**MECKLENBURG COUNTY**  
**Land Use & Environmental Services Agency**

**MEMORANDUM**

To: Charlotte-Mecklenburg Planning Commission  
From: LUESA, Mecklenburg County  
Date: 6.29.22  
Subject: Rezoning Petition Comments

**2021-258: Music Factory Townhomes**

REZONING SITE PLAN

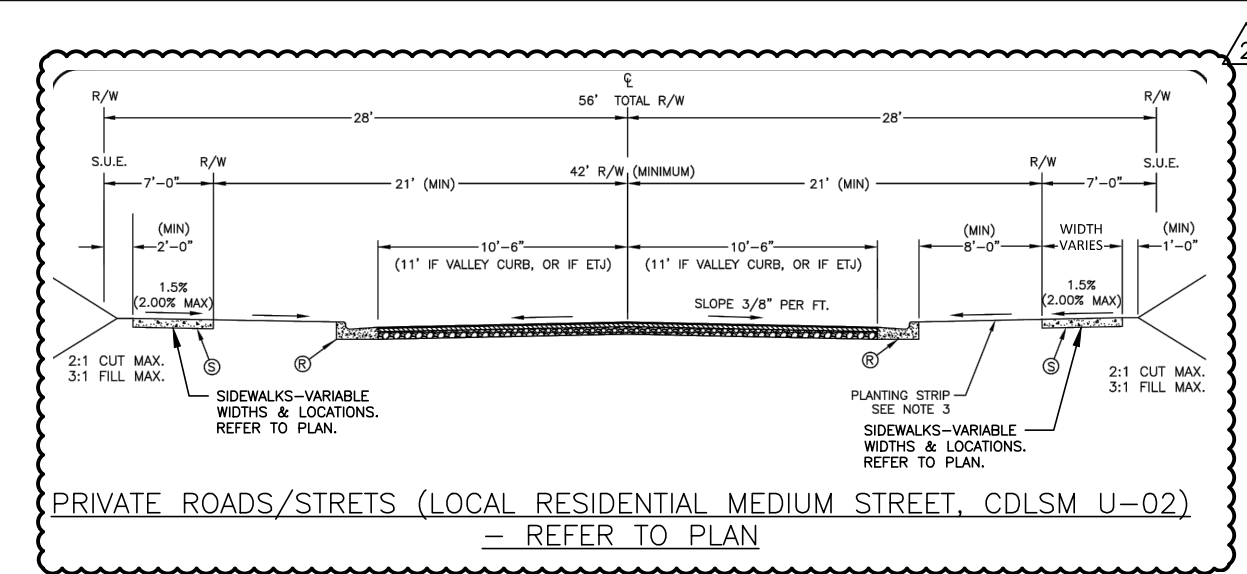
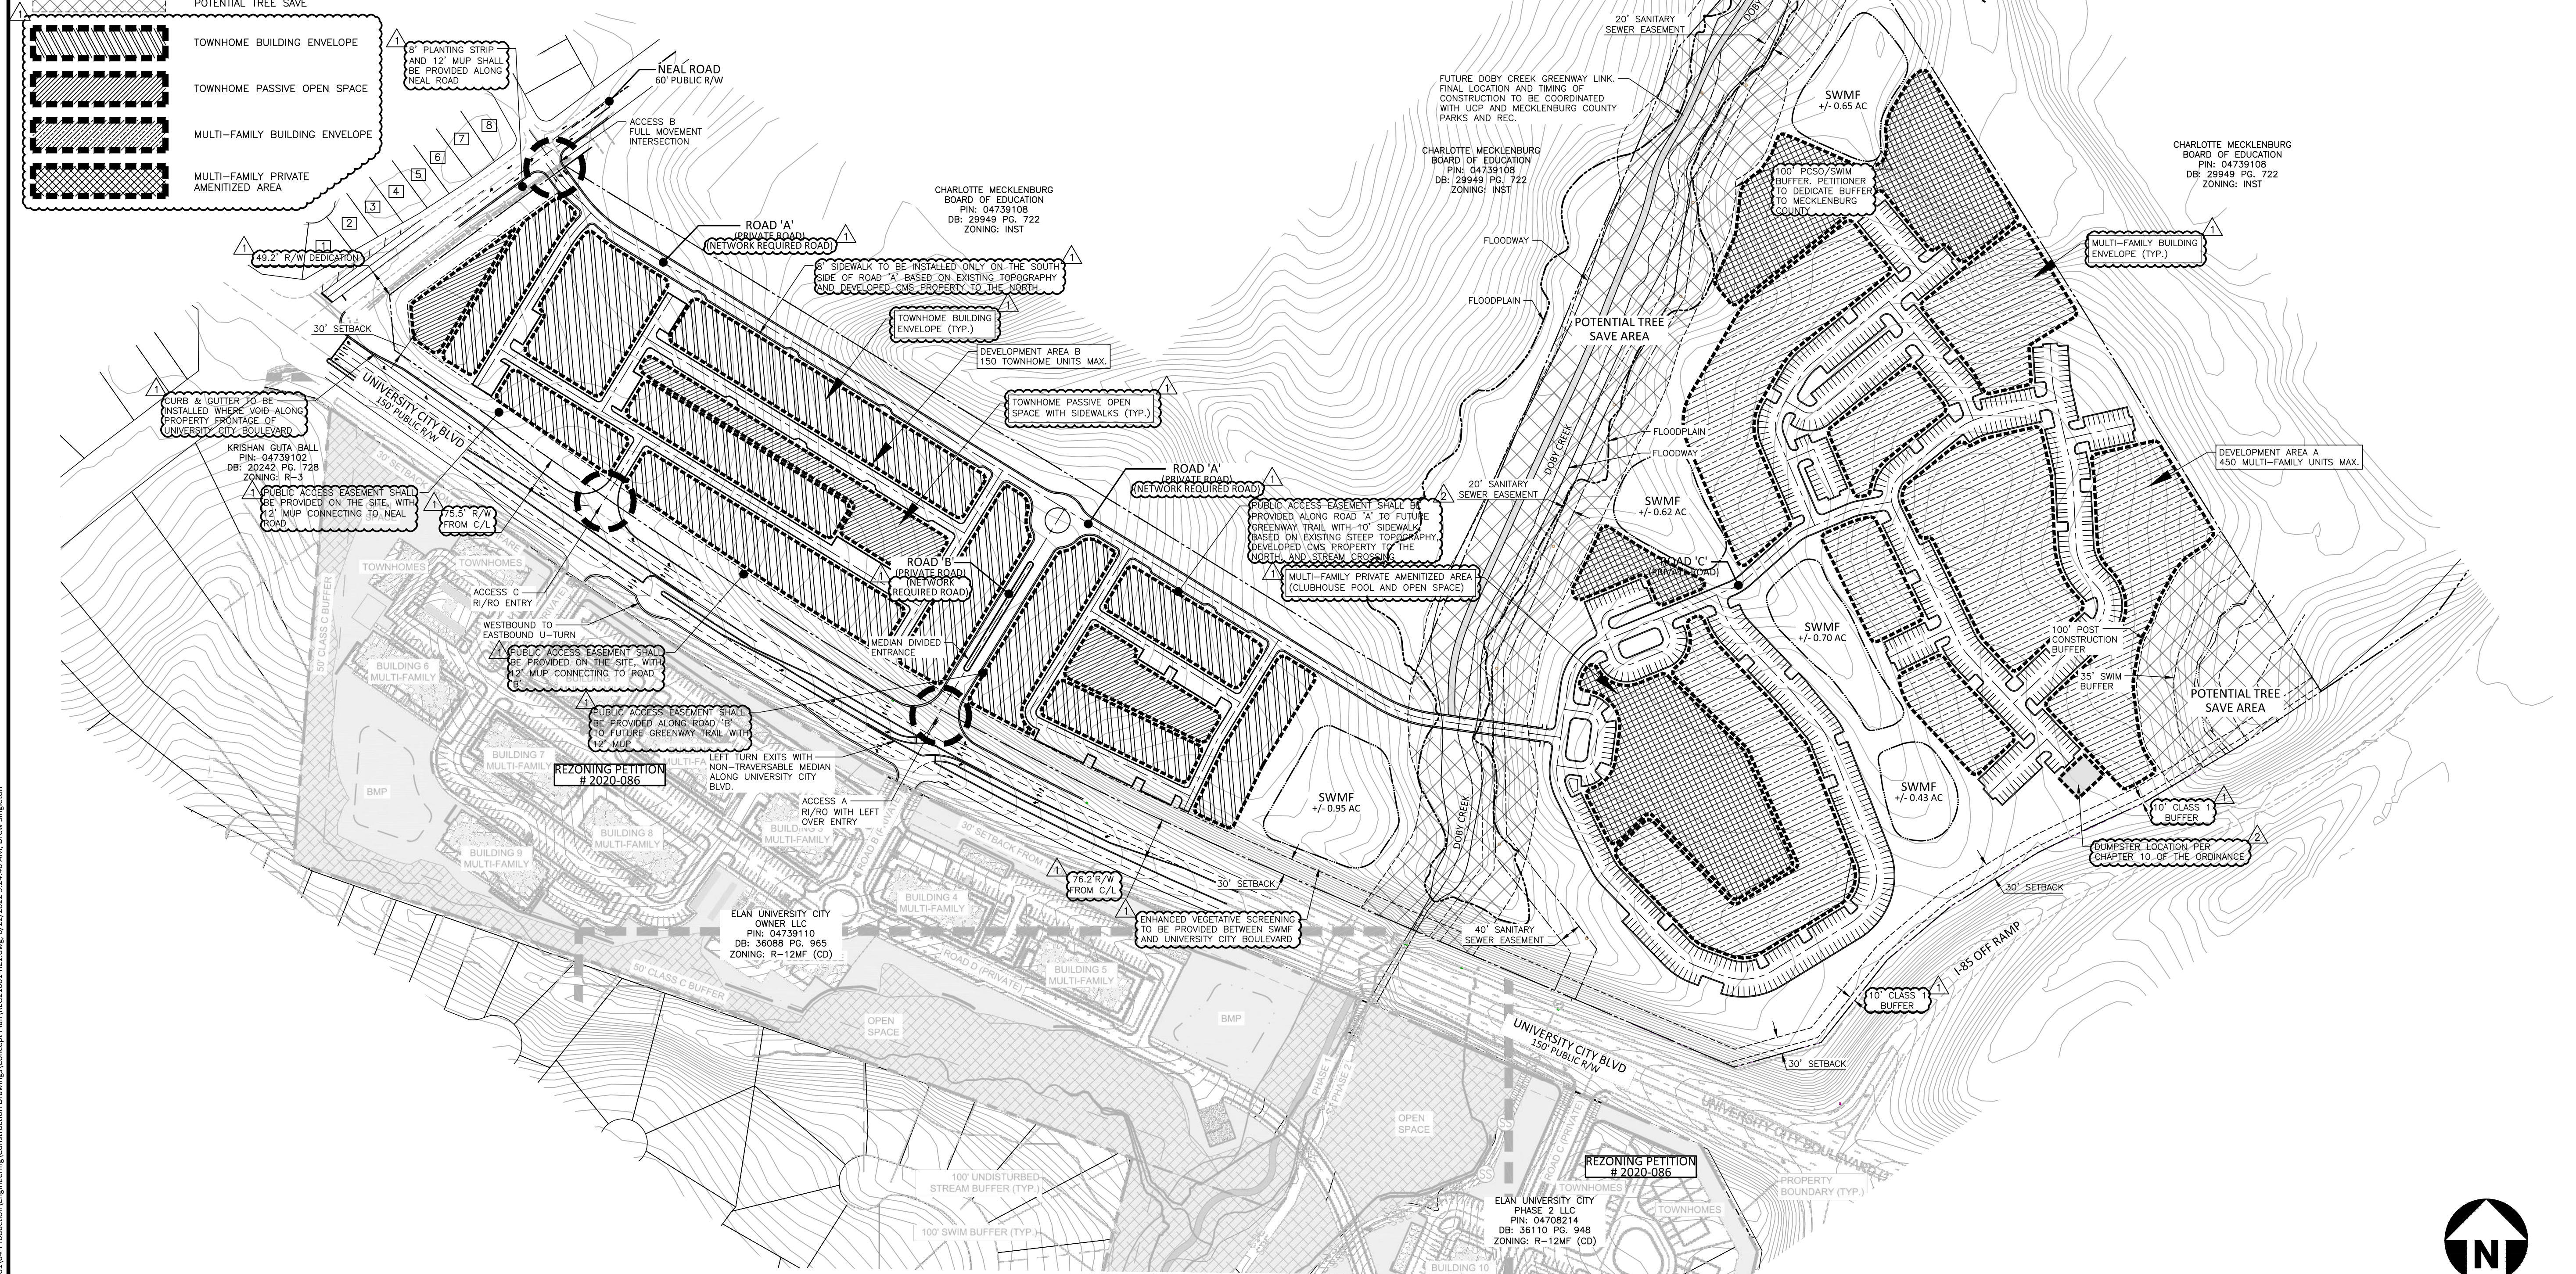
*Storm Water Services Comments:* A Floodplain Development permit must be obtained documenting compliance with the City of Charlotte Floodplain Regulations for all development occurring in the floodplain. In addition, staff recommend any structures proposed within the Community Special Flood Hazard Area be constructed to a Flood Protection Elevation equal to the Community Base Flood Elevation plus two (2) feet of freeboard based upon recent analyses of the future floodplains supported by the Storm Water Advisory Committee.
